Subject: FW: SSD 6917 MOD 1 (s96(2)) - Oakdale South Industrial Estate

Further to your email below, Council advises it has no objections to Modification 1 for the Oakdale South Industrial Estate located in Kemps Creek.

Figure 9: Southern (Bottom) and Eastern (top) Noise Walls and Setback Sections

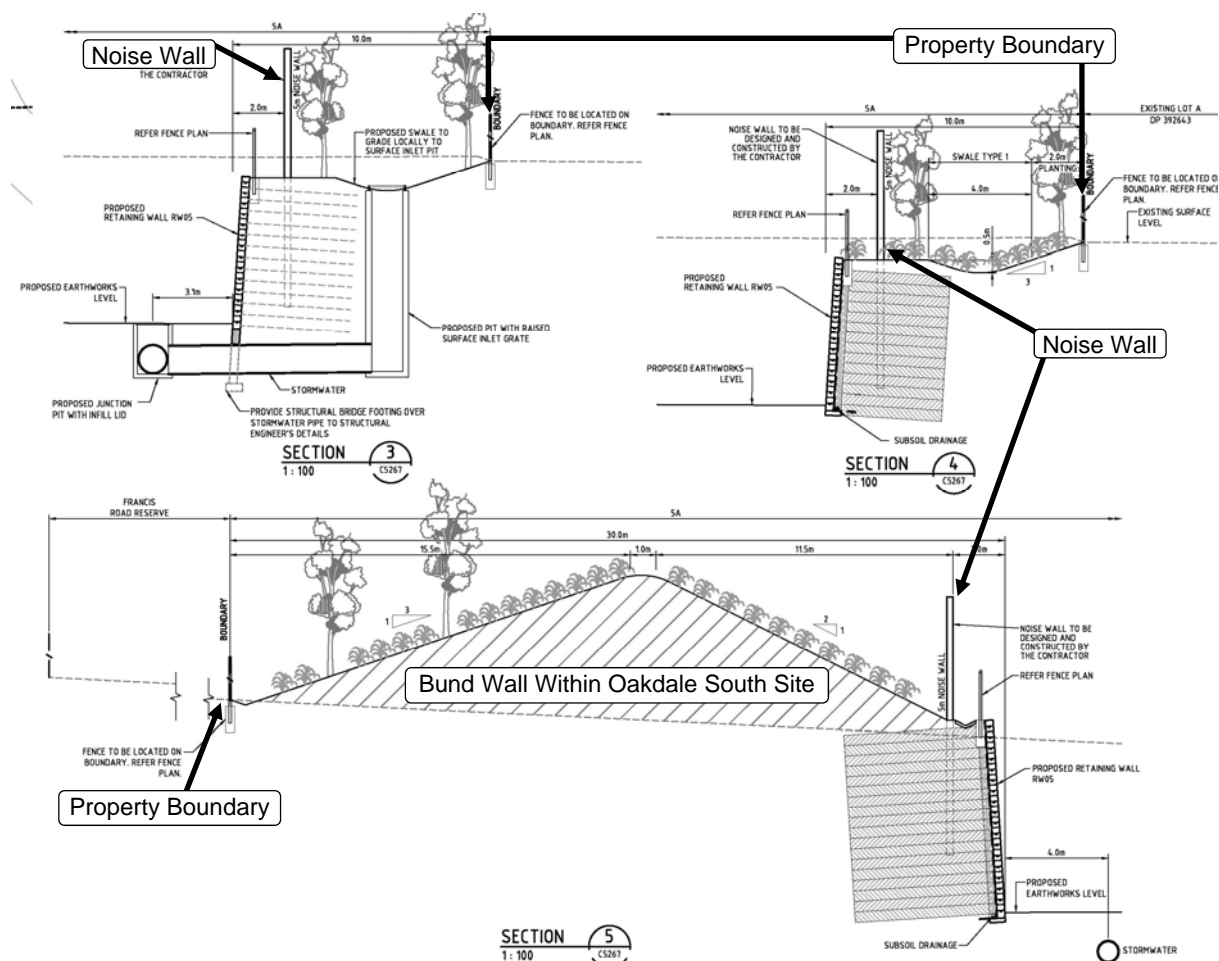
It is noted that a letter from Goodman dated 17.06.2016 – ‘Oakdale South Landscape Treatment’ associated with the ‘First Supplementary Response to Submissions’ states as follows;

“it is our intention to establish this landscape buffer concurrently with the initial phase of infrastructure works following construction of the retaining walls on this boundary”

To ensure greater clarity and certainty regarding the above commitment and to mitigate impacts on surrounding and nearby properties during the construction phase, Fairfield Council requests that a specific condition be applied to the modification application as follows;

- As part of initial phase of infrastructure works and prior to subsequent stages in the development, the required landscape buffers (including associated planting measures) and noise walls (as shown on relevant plans and elevations associated with development consent for SSD 6917) are to be constructed along the Southern and Eastern Boundaries of the Oakdale South Employment Lands to the satisfaction of Penrith City Council.
